# SYDNEY FOOTBALL STADIUM

RESPONSE TO SUBMISSIONS

LANDSCAPE AND PUBLIC DOMAIN

DATE: AUGUST 26, 2019

1 WALL TYPE 1 - PRECAST CONCRETE WALL WITH INTEGRATED TIMBER BENCH
NTS PERSPECTIVE

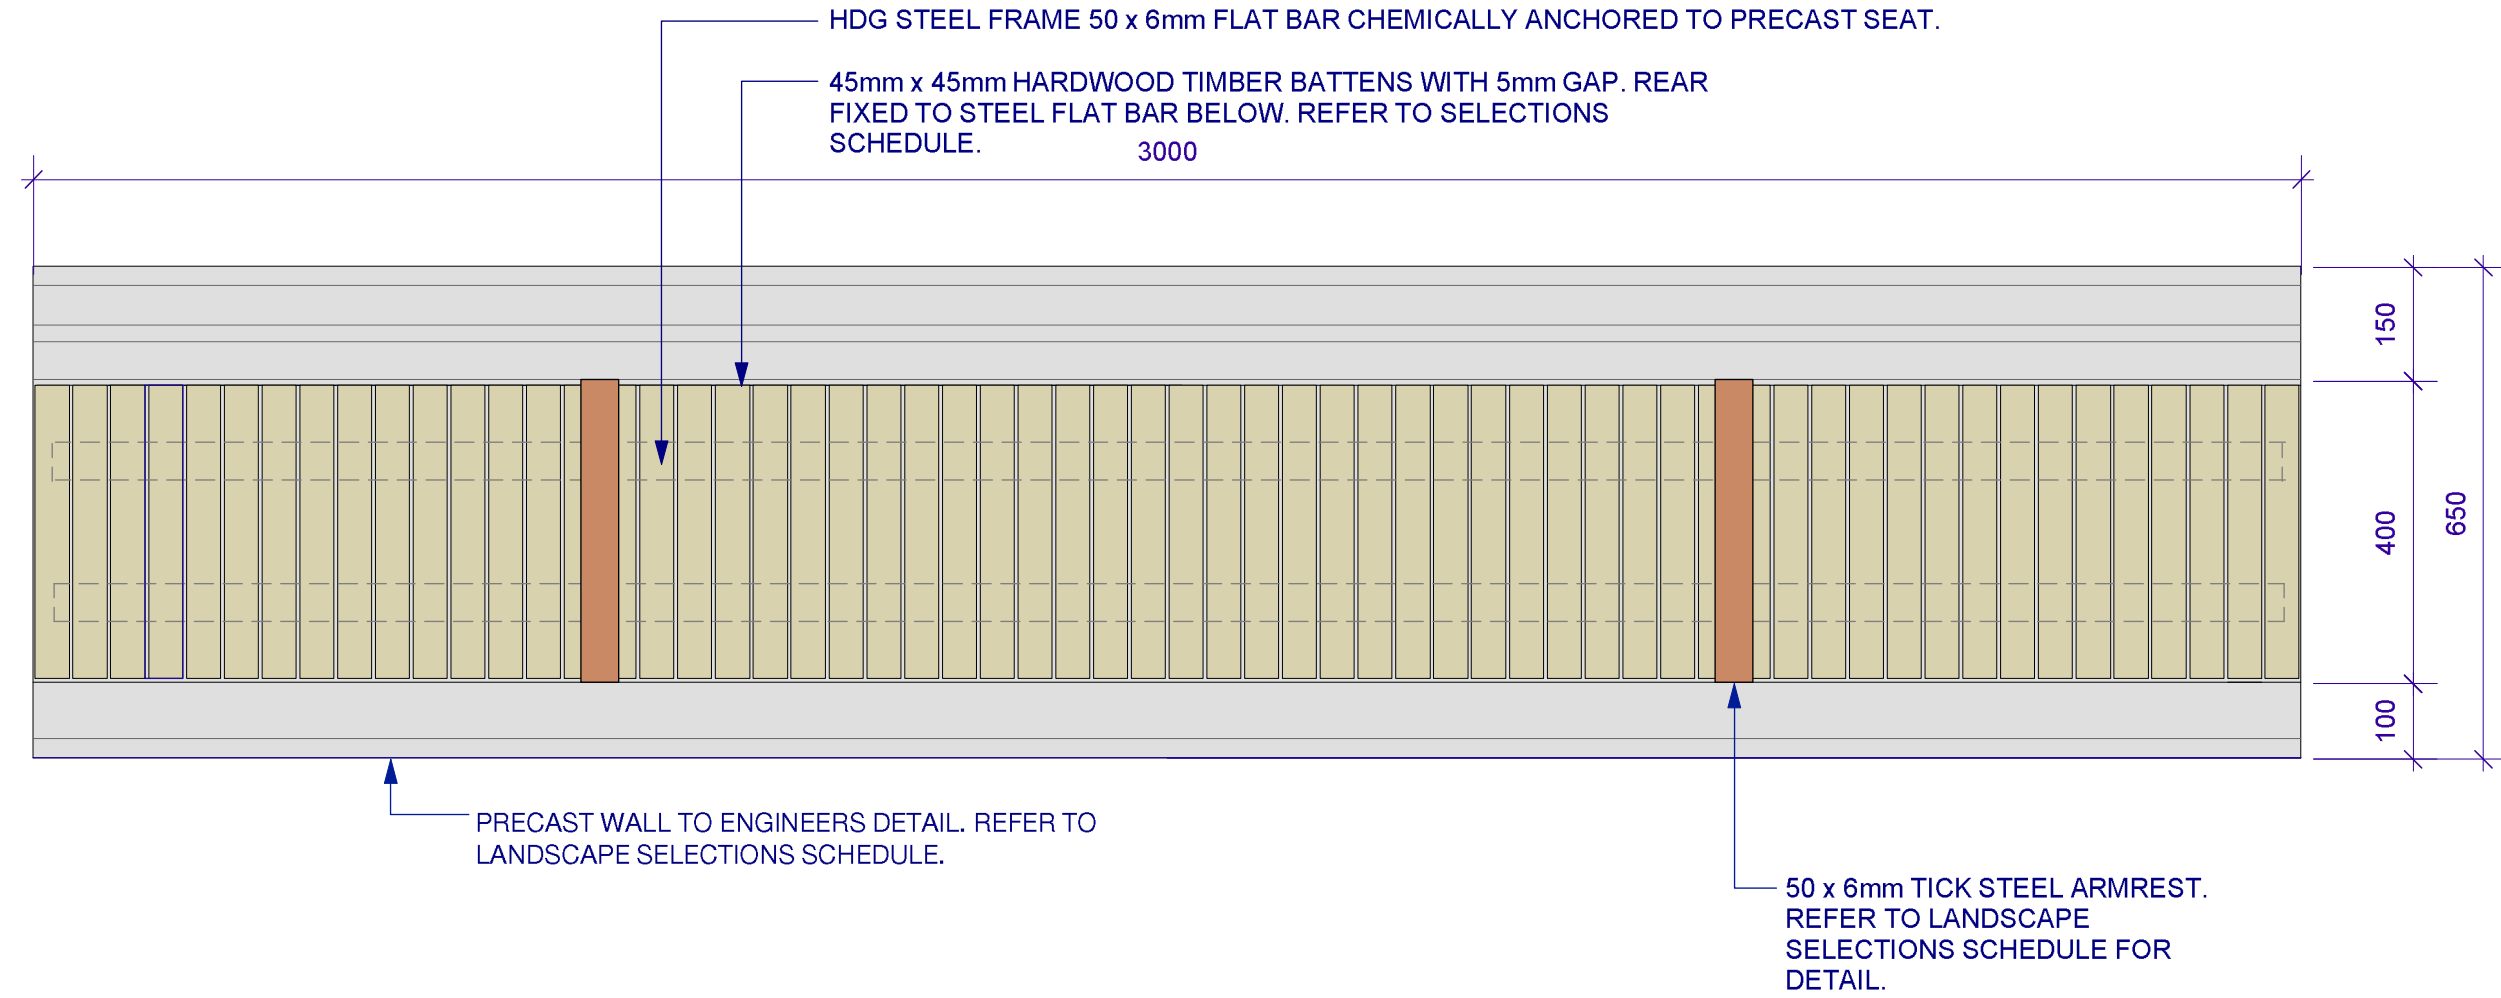
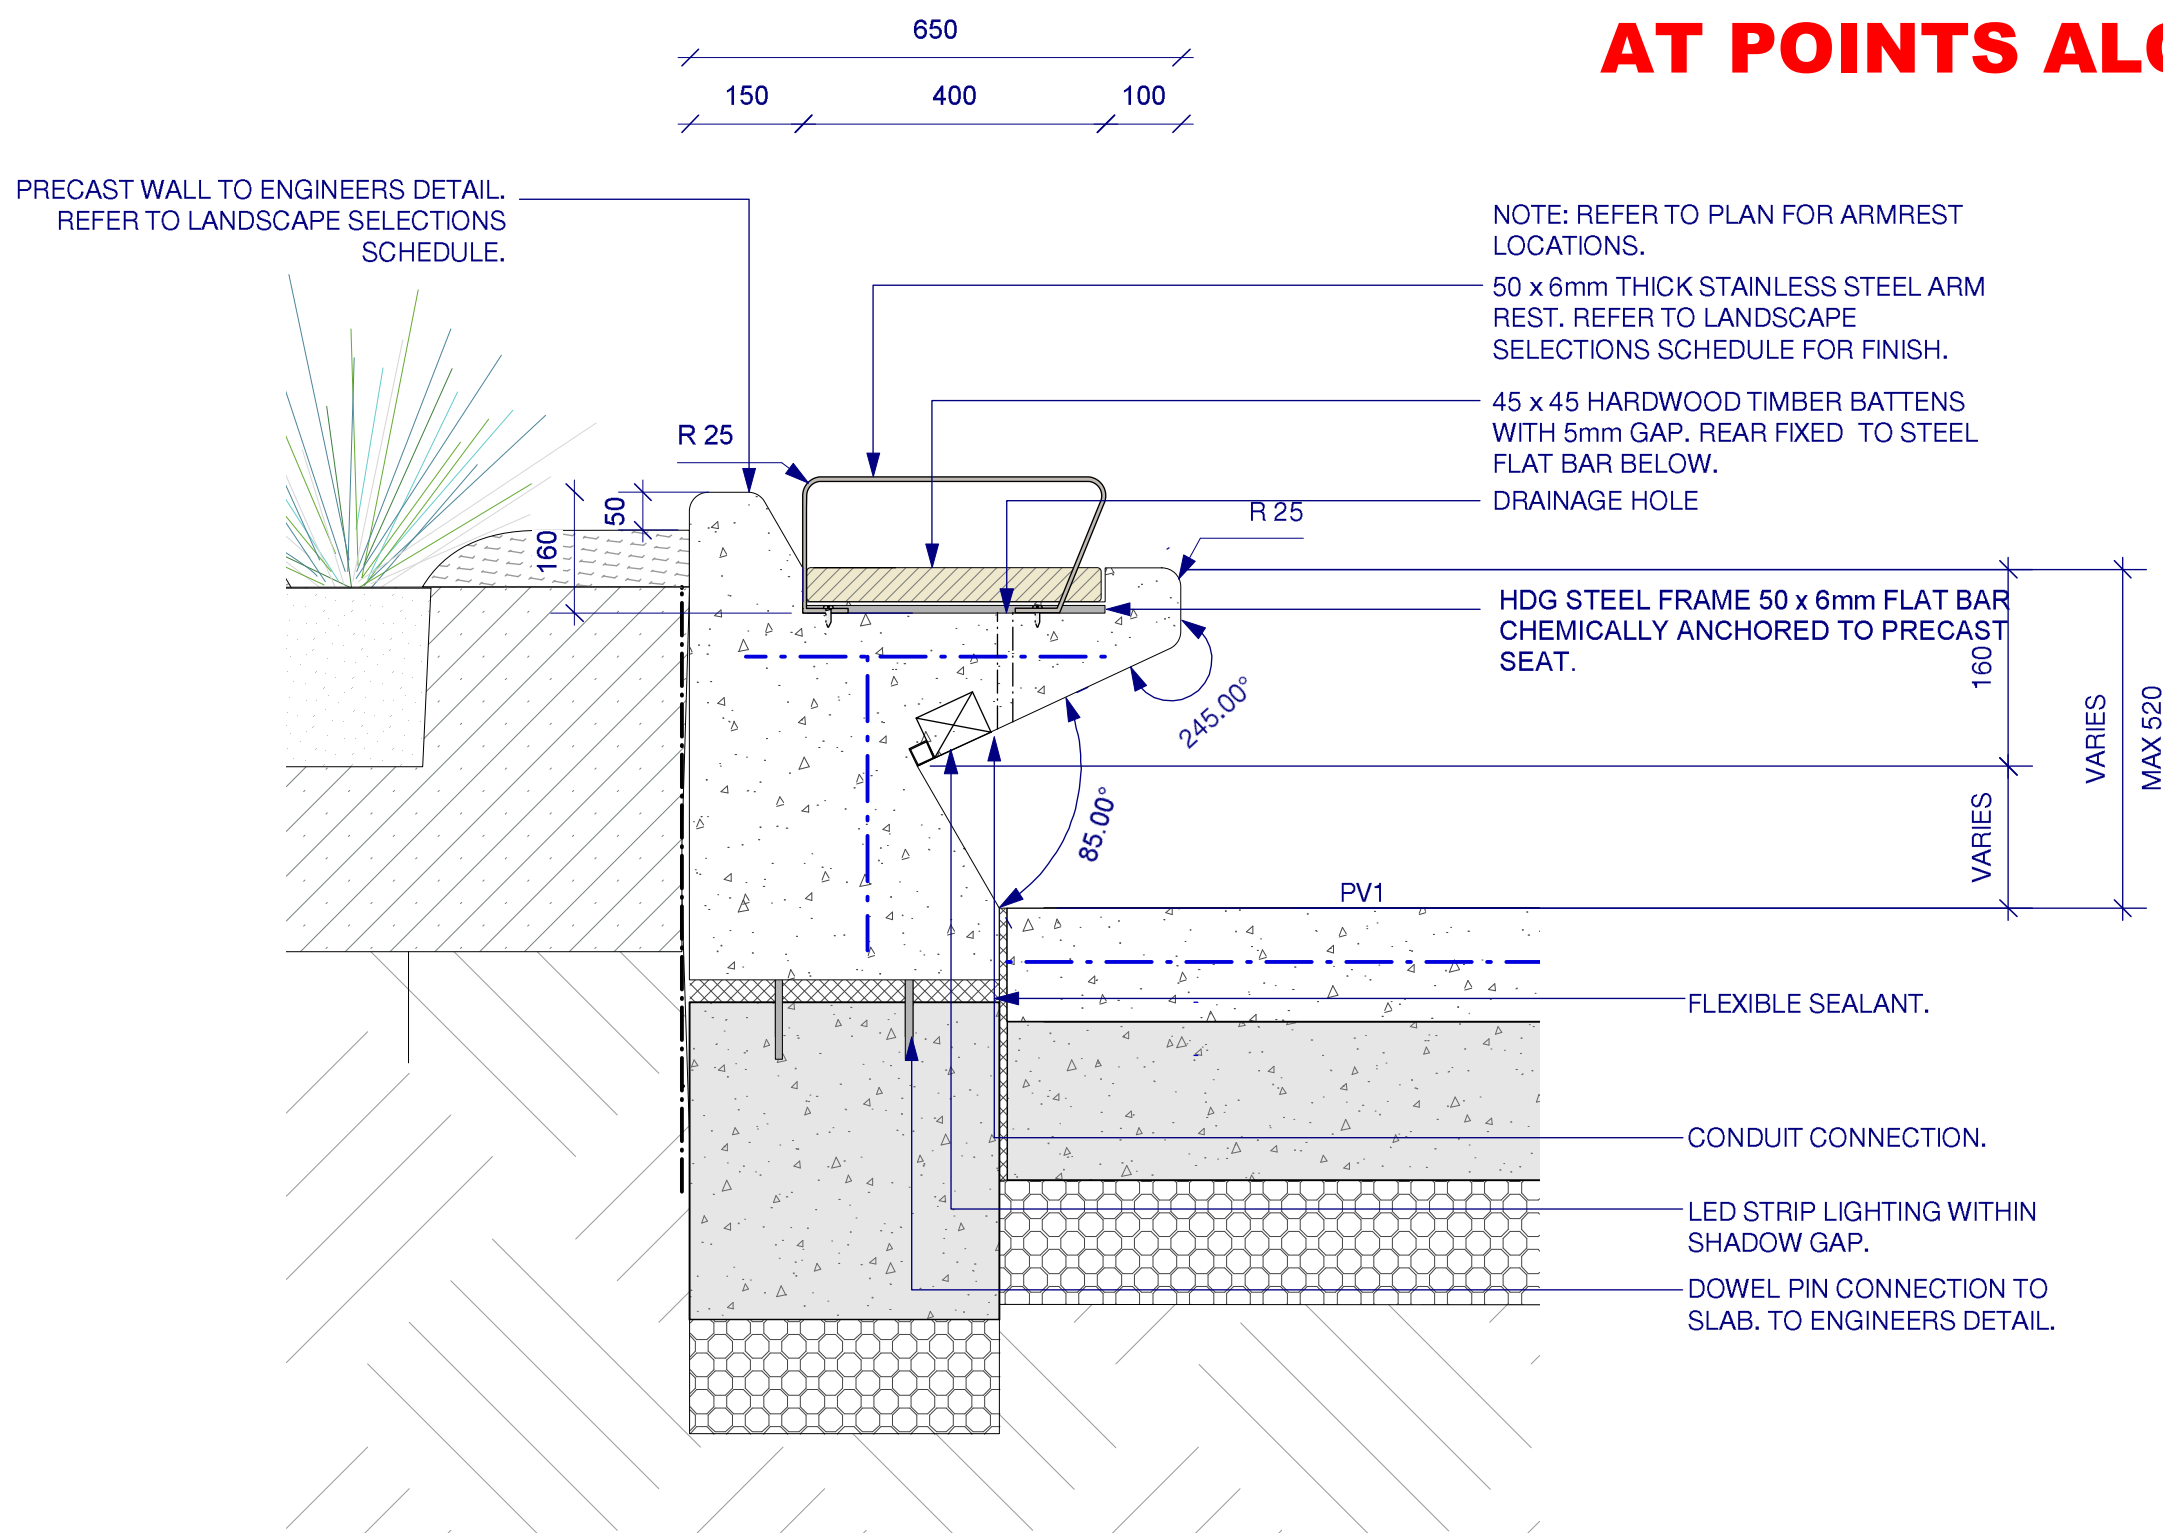
Item	Objection	Response	Public Domain Reference
1.1.2 Public Domain Materials	<p>Ensure that some integrated seating include back and arm rests to make seating more inclusive for the elderly.,</p> <p>Provide regularly recessed areas in integrated seating to enable wheelchair users and families with prams to sit together;</p>	<p>ASPECT Studios have reviewed the Draft policy and guidelines for inclusive and accessible public spaces and events and note that in principle the public domain design adheres to these guidelines and requirements and has been designed in accordance with Australian Standards, The BCA and Green Guide. The SFS Public Domain works are entirely located within the project site boundary but are inherently connected back to the CoS public spaces of Moore Park Road and Driver Ave. Providing clear and accessible connections between the site and adjoining public domain have been a key focus of this project.</p> <p>The public domain design has focused specifically on creating a public concourse that is entirely accessible – achieved via max 1:20 walkways. In some areas 1:14 ramps have been utilised; however these are located away from zones with consistently large pedestrian volumes.</p> <p>To achieve an accessible concourse with flush entries into the stadium, the concourse has been raised to the Moore Park Road Level affording predominantly flush connections in to the site for the majority of the northern boundary (which is currently inaccessible). Stair access has been introduced at the Driver Ave connection at the pinch point between the existing NRL building and cricket practice wickets. Two public lifts are located in this area to provide access to the concourse (a ramp in this location would exceed the BCA requirements for ramp rise).</p> <p>While considered in the current landscape works, further detailed design of furniture, kick rails, shorelines, artwork integration and signage will be refined in future stages of the project and will be designed to comply with these policies and guidelines.</p> <p>Specifically, ASPECT Studios will update Wall Type 1 to include backrests to provide additional integrated seating. Note, Armrest are already provided.</p> <p>Spaces have been designed to be inclusive and to consider wheelchair users and families with prams. See examples provided.</p> <p>It is anticipated that a final Landscape Plan, prepared prior to construction commencing, will detail the furniture design.</p>	 <p>Wall Type 1 Detail - Refer to Appendix 1.</p>
